State of Washington
DEPARTMENT OF FISH AND WILDLIFE

May 11, 2018

RE: LP-18-00001 Suncadia Phase 1 Division 15

Site Development Plan MPR Phase 1 Division 15 March 20, 2018

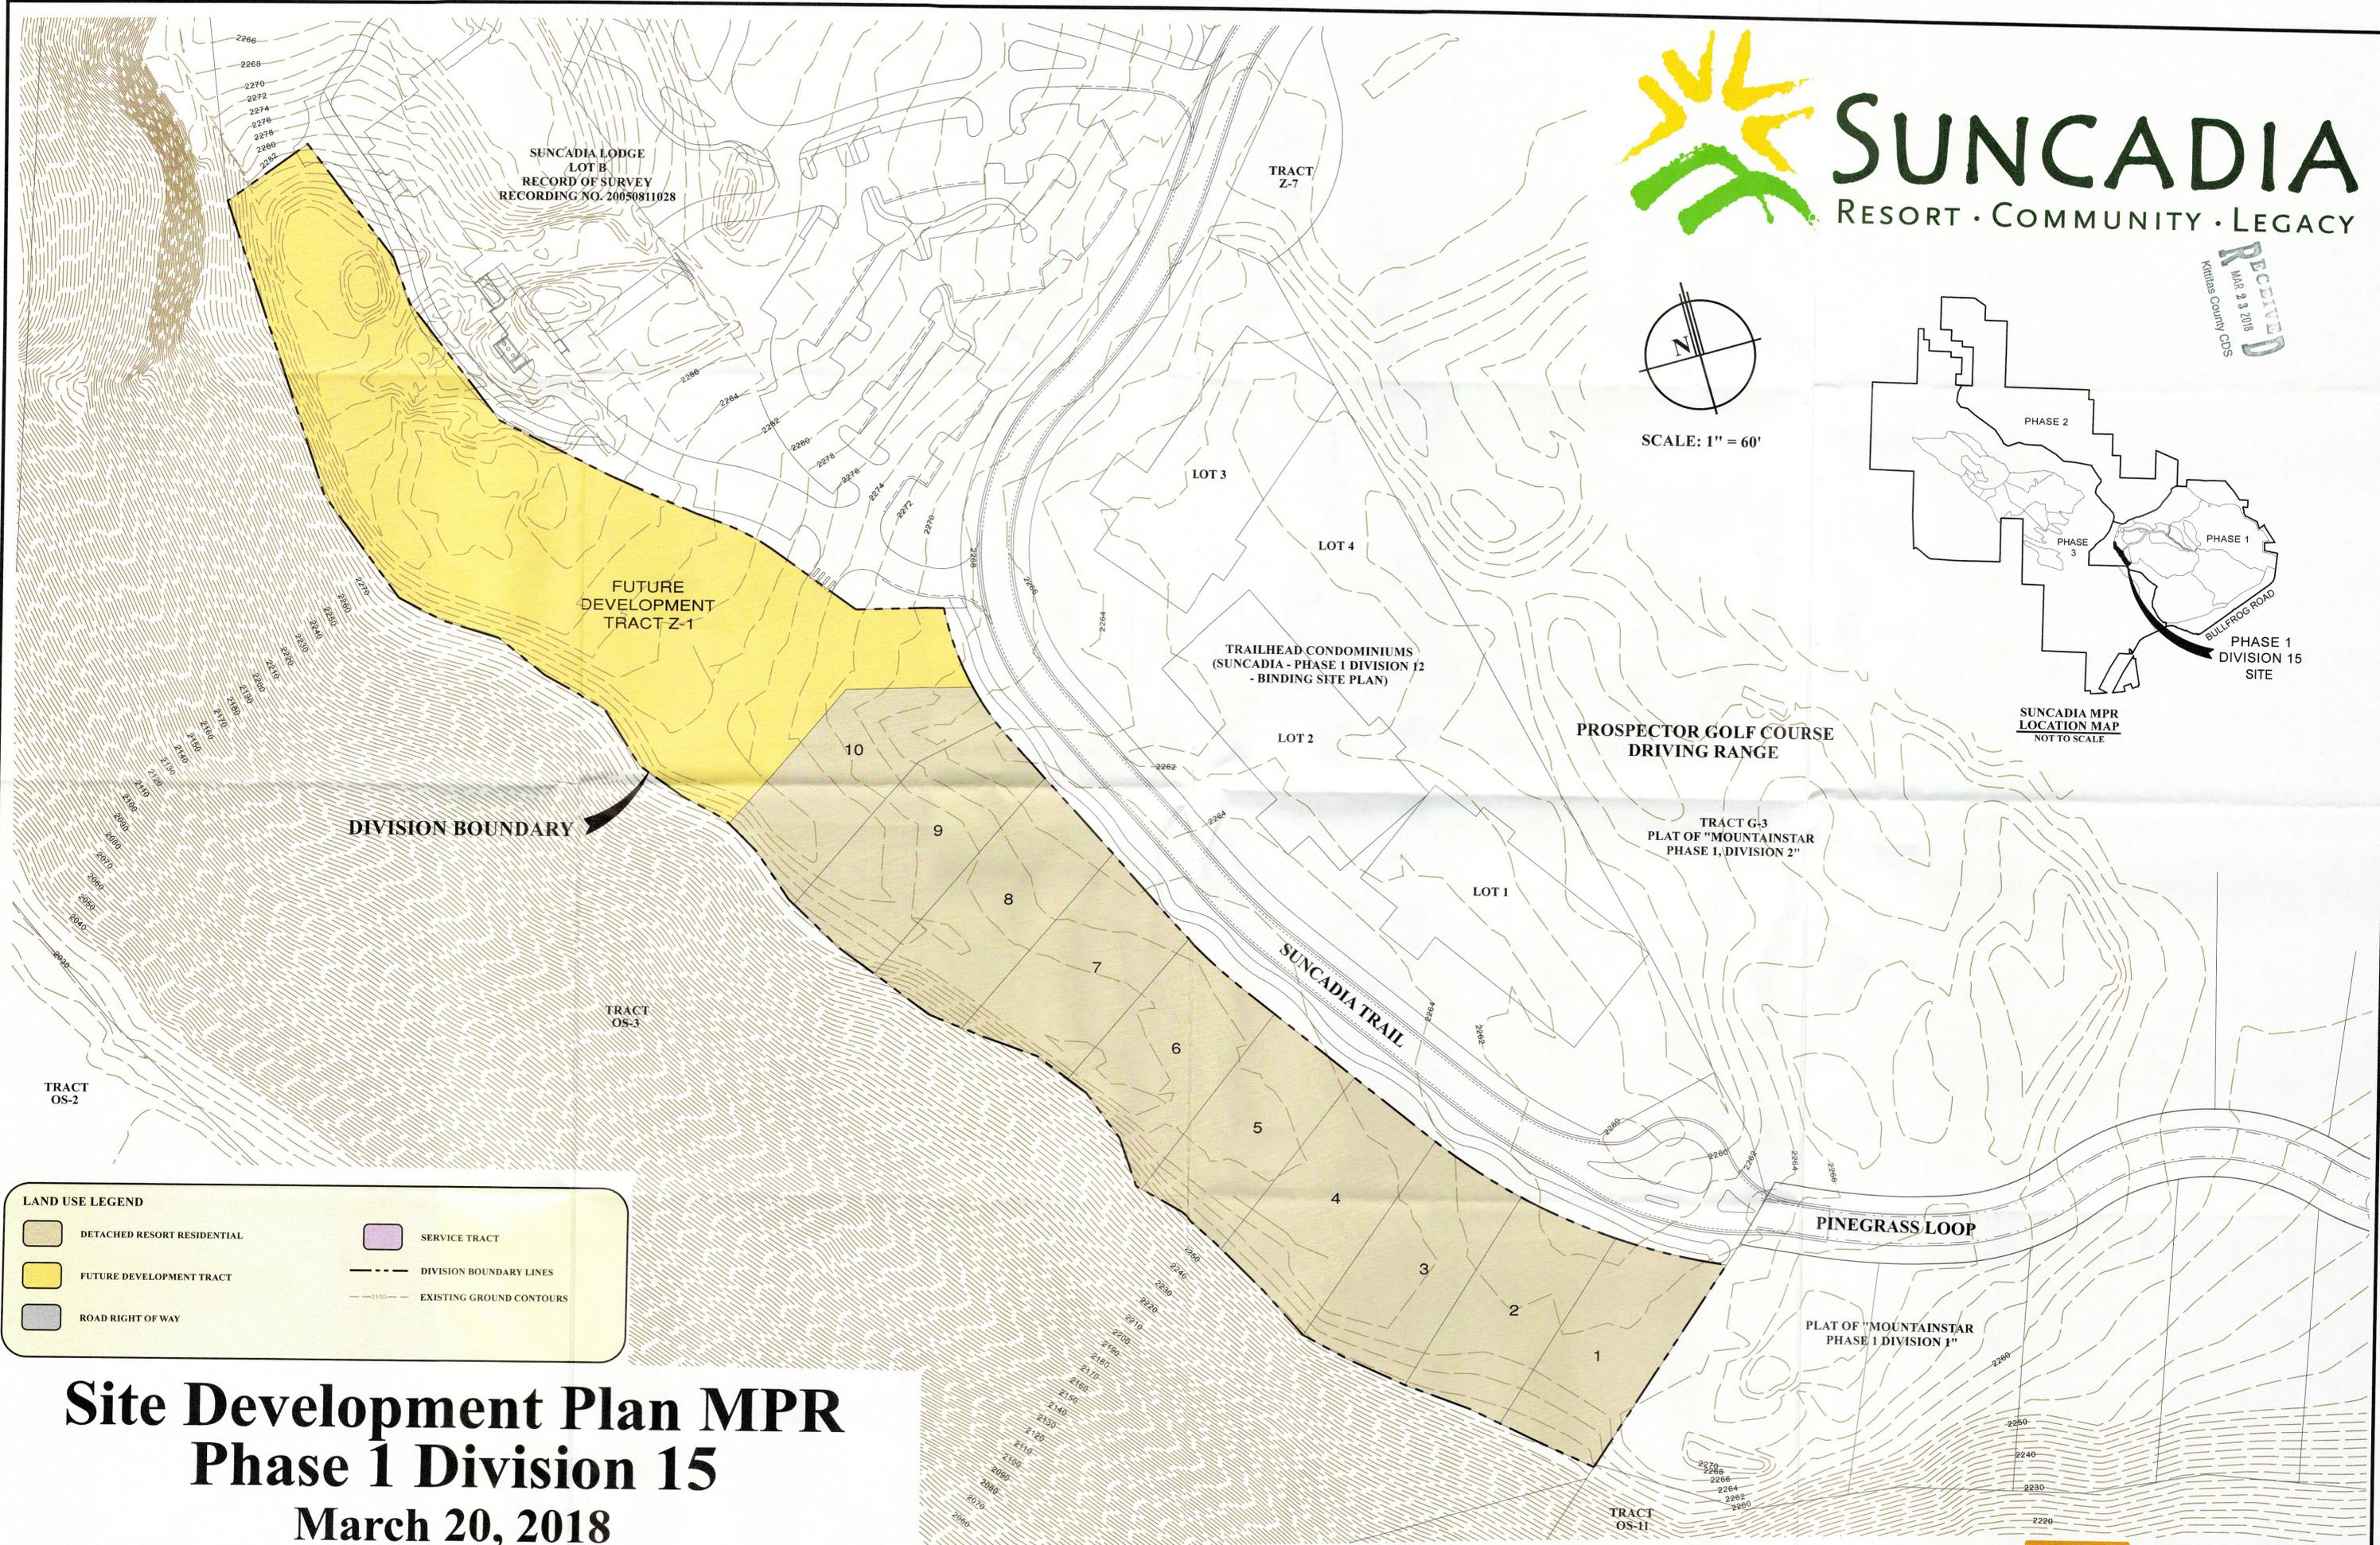
--The proposed lots are directly adjacent to a steep slope which is designated as managed open space and has adjacent connections to the Conservation Easement for the Suncadia MPR. It is critical that trees on this slope behind the home lots be retained as they provide both critical habitat values and slope stability, which if eroded could endanger both the homes at the top of the slope as well as the river corridor at the bottom of the slope. Based on the location of these lots, view shed will likely be emphasized and height of the trees on the slope may affect future view shed. If these lots are permitted, WDFW requests that it be stated in conditions of approval that no clearing or cutting of trees be allowed on the adjacent open space hillslope without approval from Kittitas Conservation Trust (KCT) as is stipulated in the open space agreement.

--WDFW believes that the open space calculations shown in the application do not reflect the correct current calculations of open space for the Suncadia MPR. Please have the applicant verify the open space calculations with current up to date information.
